ONE STOP COMMENT FORM

DRB Case No. 1002012 SP No: D2DRB-00902 S No: _____
Project Name: TIMOTEO CHAVEZ Fee: \$ Paid? Yes No
Agent: Adv. Eng. & CONSULTING Phone No: 899-5570, Shawn
897-4996 FAX

Request For: Site Development Plan for Building Permit/Subdivision
 Site Plan Amendment
 Extraterritorial Zone (ETZ) Subdivision
 Minor Plat
 Vacation - private easement

**PLAT OF
LOT 9-A, BLOCK 3
TIMOTEO CHAVEZ ADDITION**
WITHIN SECTION 11, T. 10 N., R. 3 E., N.M.P.M.,
ALBUQUERQUE, BERNALILLO COUNTY, NEW MEXICO
MAY, 2002

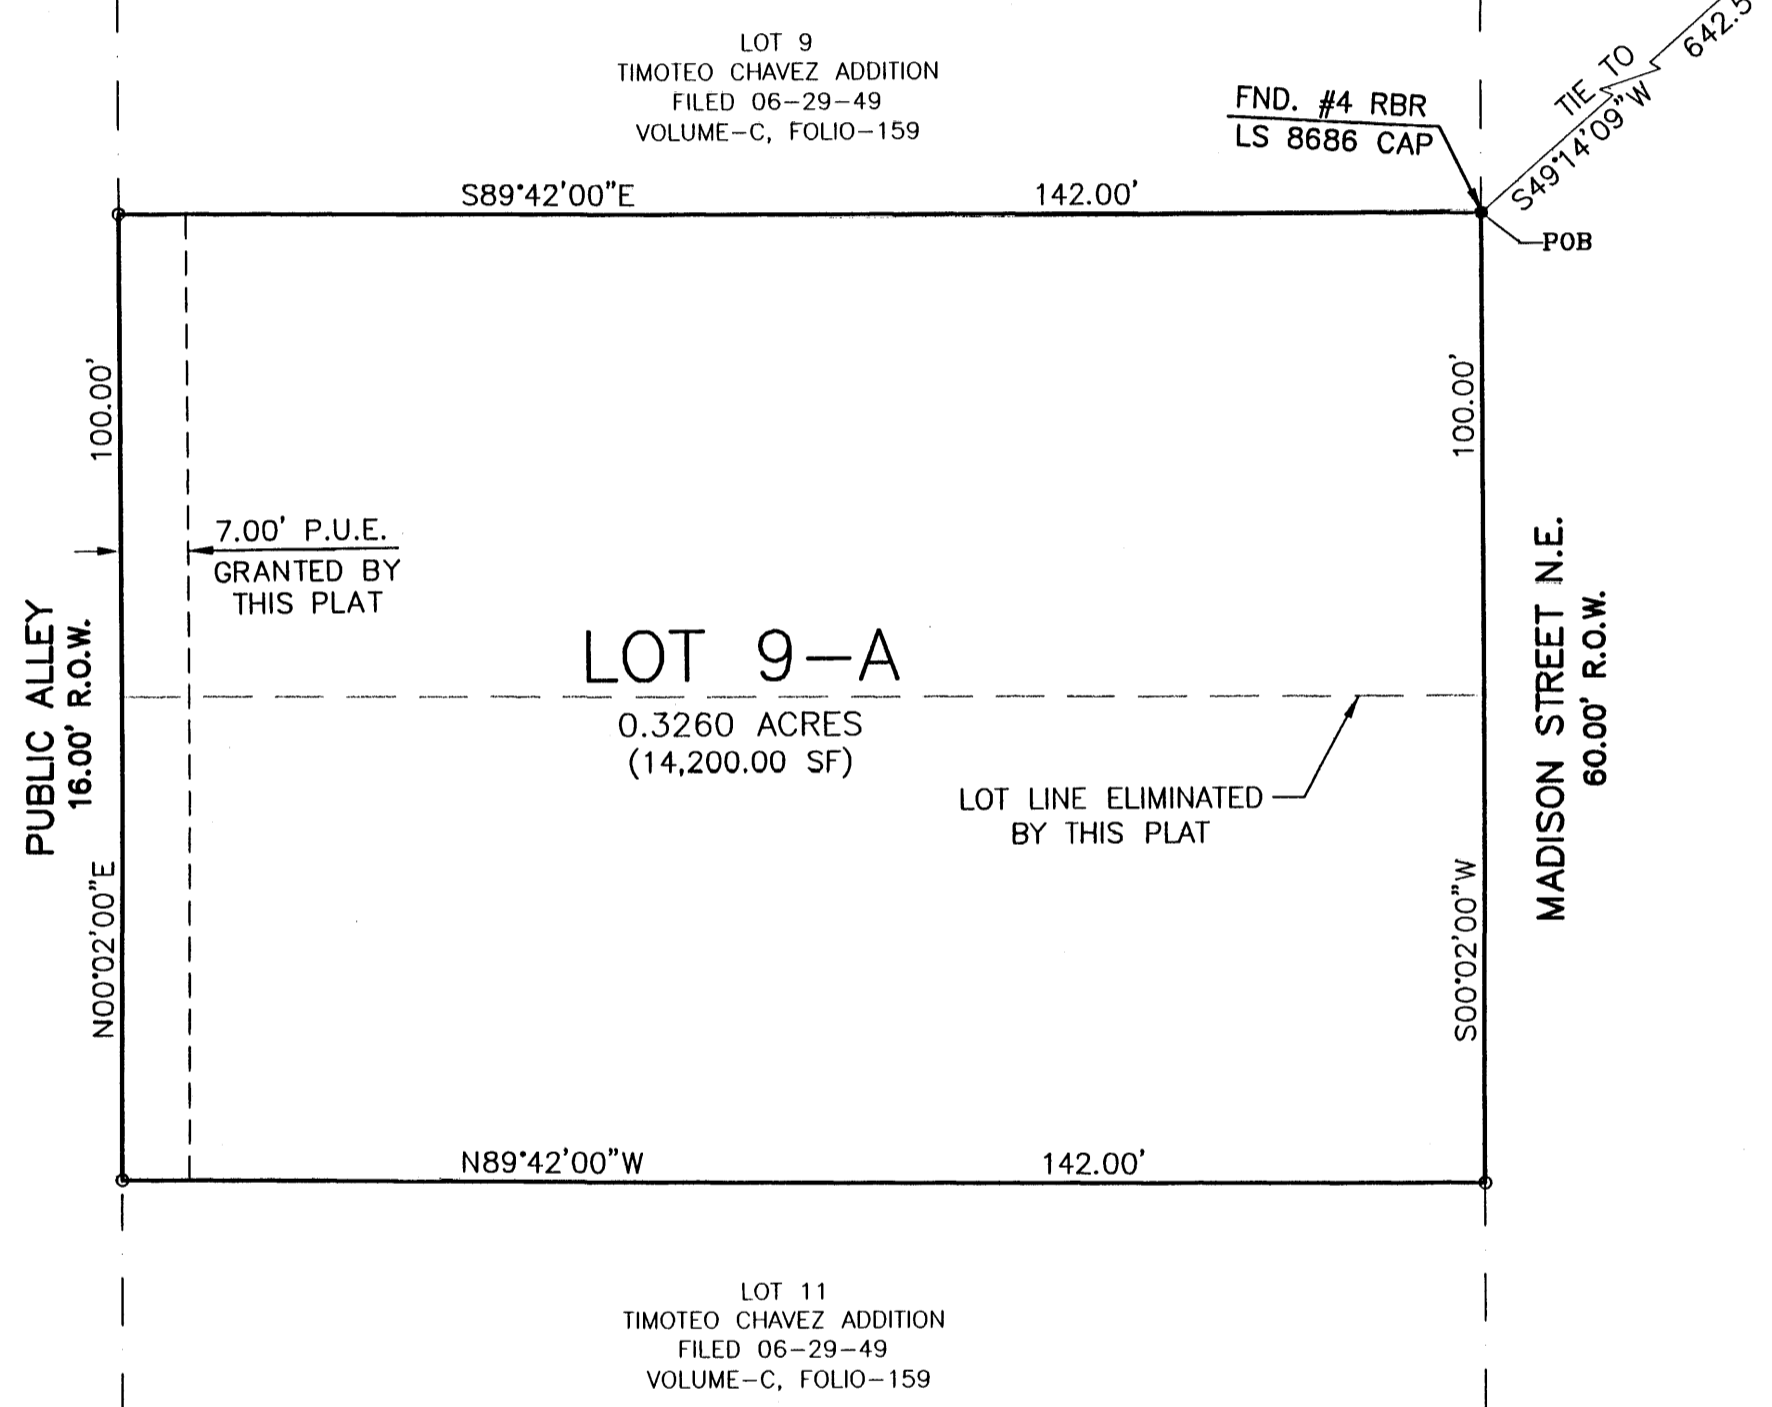
COMMENTS: ① Minor plats may be recorded by the applicant/agent. A copy of the recorded plat must be provided to Planning in order to close the case file. ② Please provide a digitized dxf file of right-of-way parcel & easement lines shown on the final plat in New Mexico State Plane Feet NAD 1927.
